Tween Bridge Solar Farm

9.9 Statement of Common Ground with Natural England

Document Reference: 9.9

Revision **23**

Figure 2: Non Breeding Bird Mitigation Plan – No Annotation

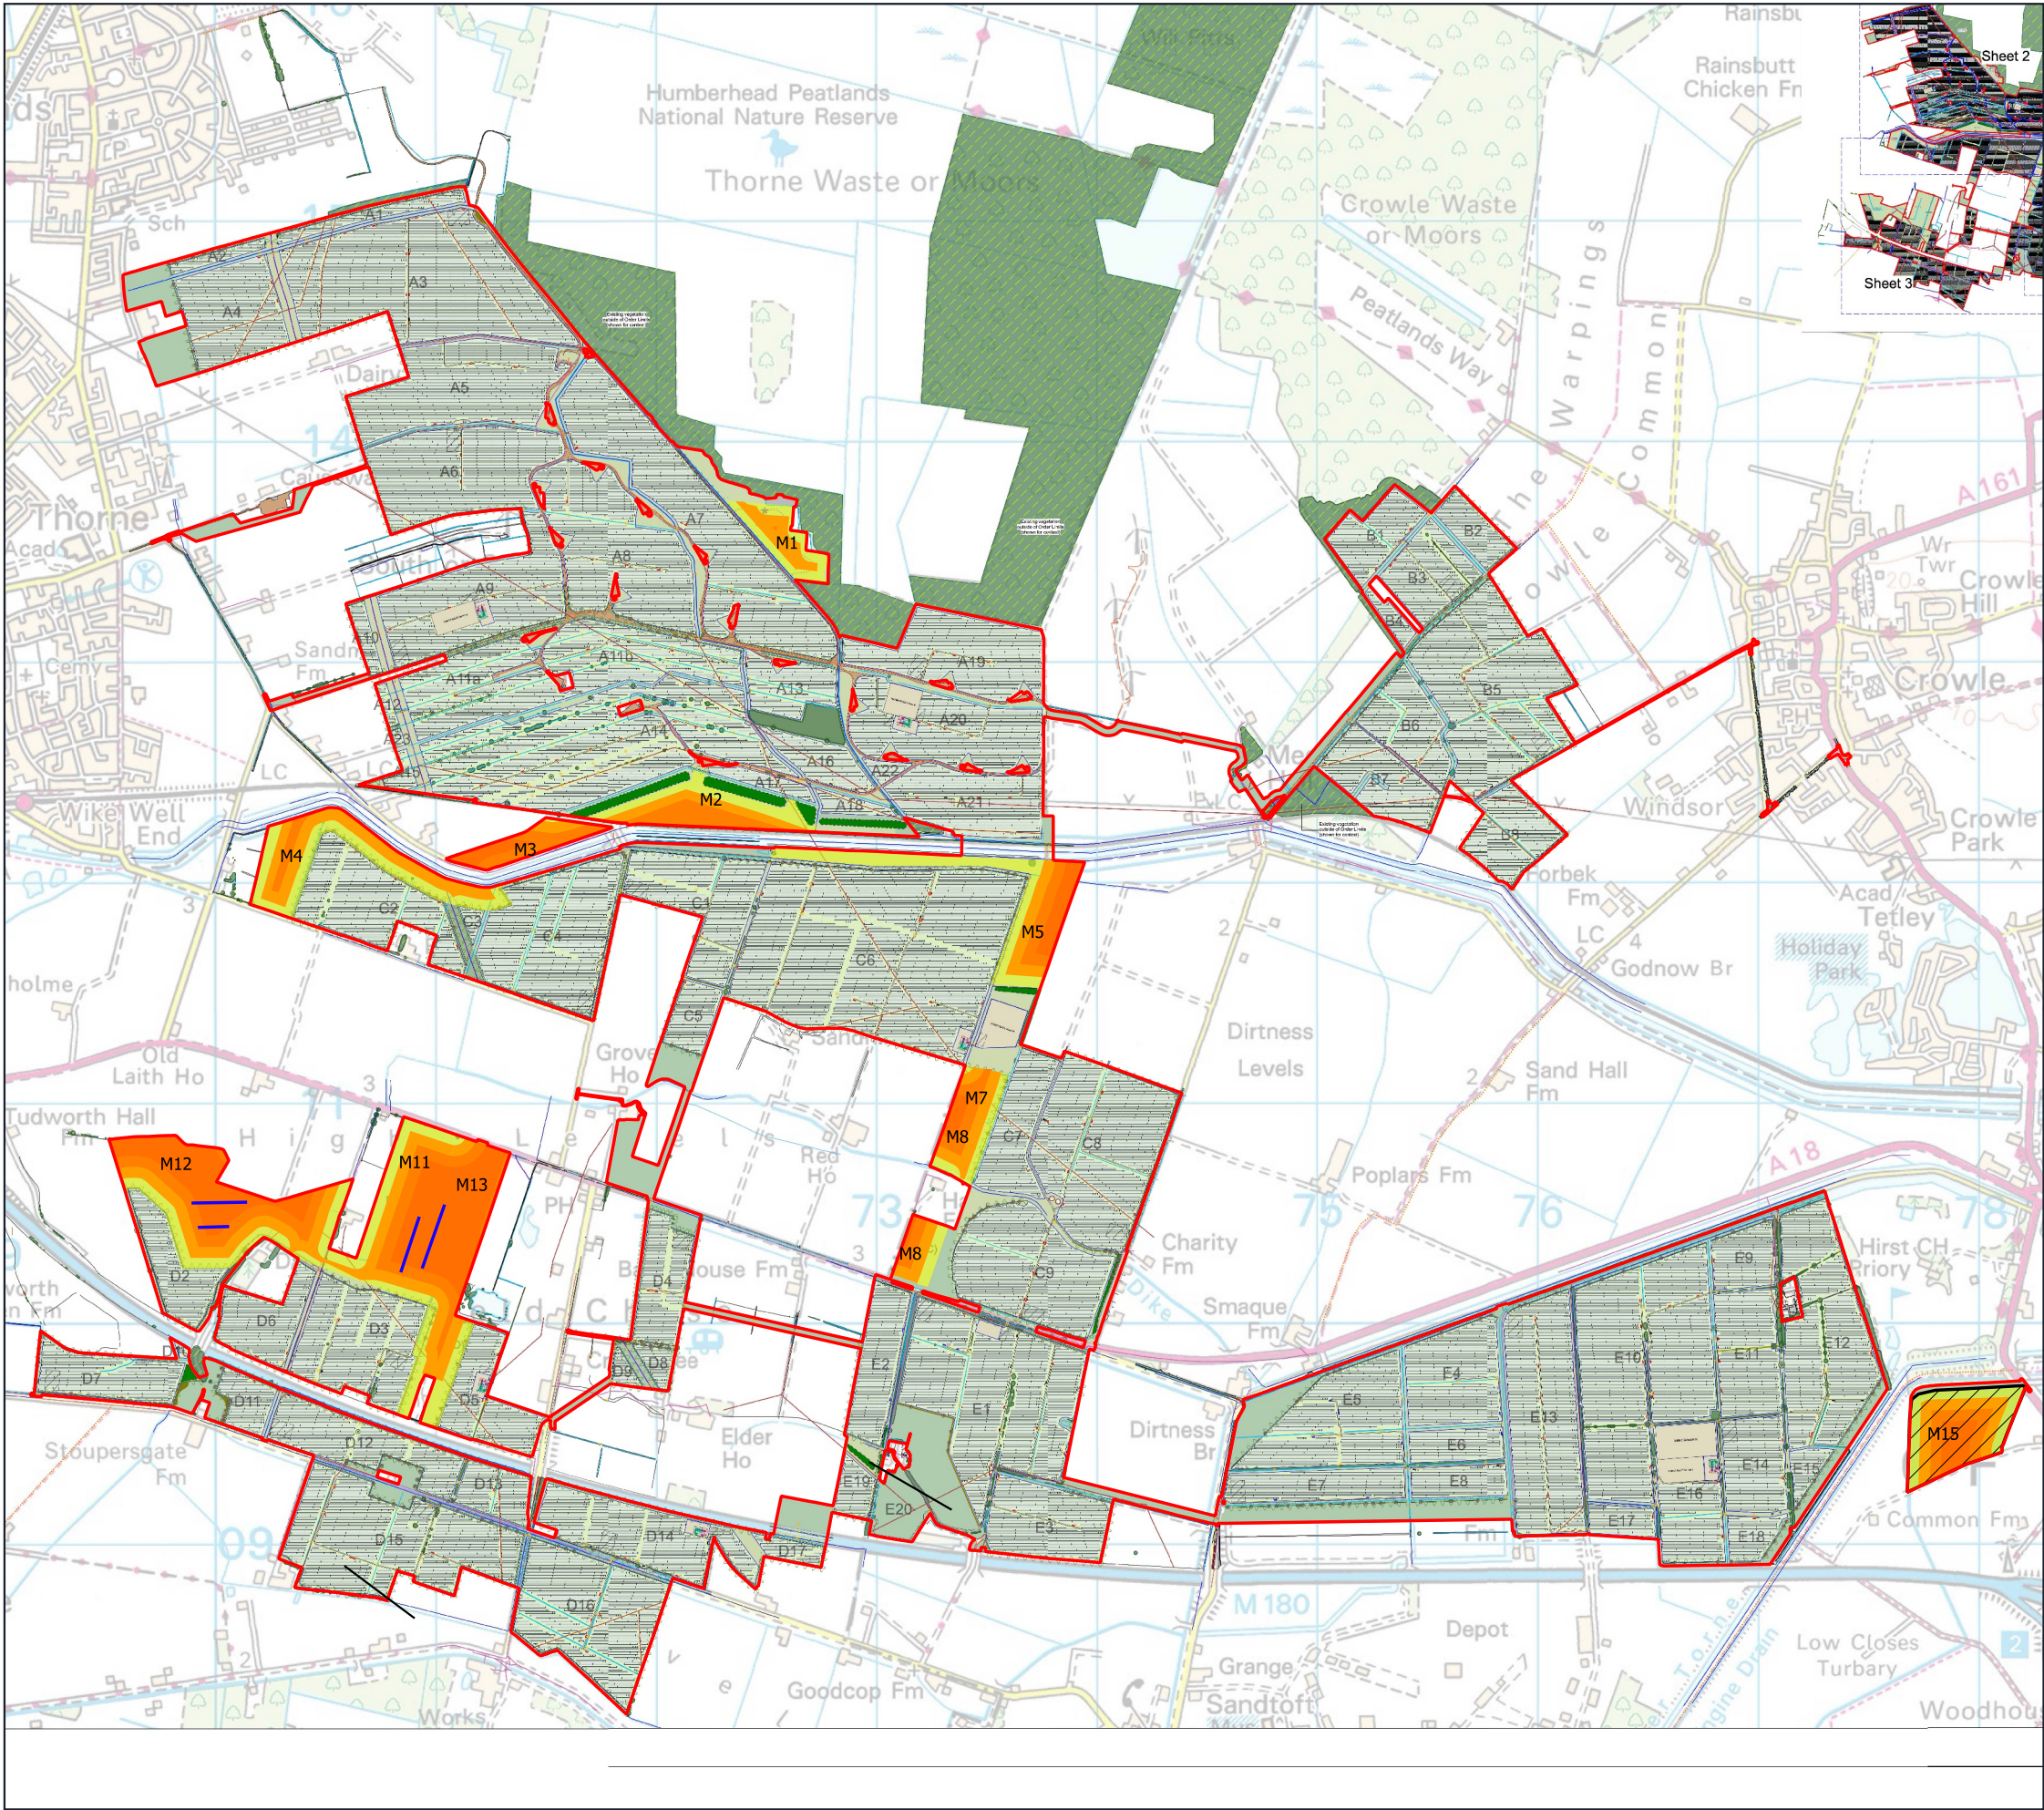
adversely impacted, alternative sites should be considered. Cannot locate figure — Please provide further details As stated in email in Appendix, although an NE ornithologist confirmed that the calculations look fine, NE doesn't have a nationally recognised method of using bird days in this way within terrestrial ornithology. We highlighted that as mentioned previously, ecological knowledge should supplement the calculations to demonstrate that there is suitable habitat provision for the numbers of birds displaced by the development. Request these clarifications are provided here: We confirm this remains under discussion — We welcome that some additional detail has been provided here, however, we request that further assessment in updated documents	The Applicant confirms that Figure:16413_P16a_600m Buffers_TLR_RR is attached at the end of this document. The Applicant confirm that the use of ecological knowledge has been used to supplement the bird days calculations to demonstrate that there is suitable habitat provision for the numbers of birds displaced by the development. The Applicant confirms that further detail on monitoring for collision risk is included in the Outline Landscape Ecological Management Plan [Document Reference 7.6 Revision 35] submitted at Deadline 2.

ecological knowledge of the species being mitigation. The Applicant confirms that 108.84ha is in addition to 43.67ha. As detailed in Table 1-1: Non-Breeding Bird Mitigation Land Calculations at the end of this document, and shown in Figure 1: 16413_P16a_600m Buffers_TLR_RR, at the end of this document. The Applicant confirms that reducing in extent parcel M1 would not affect the mitigation strategy and that sufficient mitigation is provided without the inclusion of M1, based on using Bird Days calculations, the habitat requirements and ecological knowledge of the species being mitigated. Table 1-1: Non-Breeding Bird Mitigation Land Calculations at the end of	
--	--	--	--	--

<u>these areas, as demonstrated by updated Figure P1 (16413_P16a_600m Buffers_TLR_RR). Therefore, mitigation land is being provided and secured in areas of existing bird usage, in line with point NE1 'securing areas of higher existing bird usage'.</u> <u>Nonetheless, the majority of mitigation areas proposed are located well beyond 600m of any turbines, including all of areas M4, M7, M8, M11, M12, M13 and M15, and the majority of M3 and M5, totalling 152.51ha out of the total 187.32ha proposed. This ensures that there is sufficient mitigation land provided beyond 600m of turbines, as demonstrated by the Bird Days calculations, which Natural England have confirmed are accurate (see email correspondence dated 10.07.2025 – see Appendix 1), and which have been completed in addition to ecological knowledge of the carrying capacity of different habitat types, which is also in line with</u>	
--	--	--	--	--
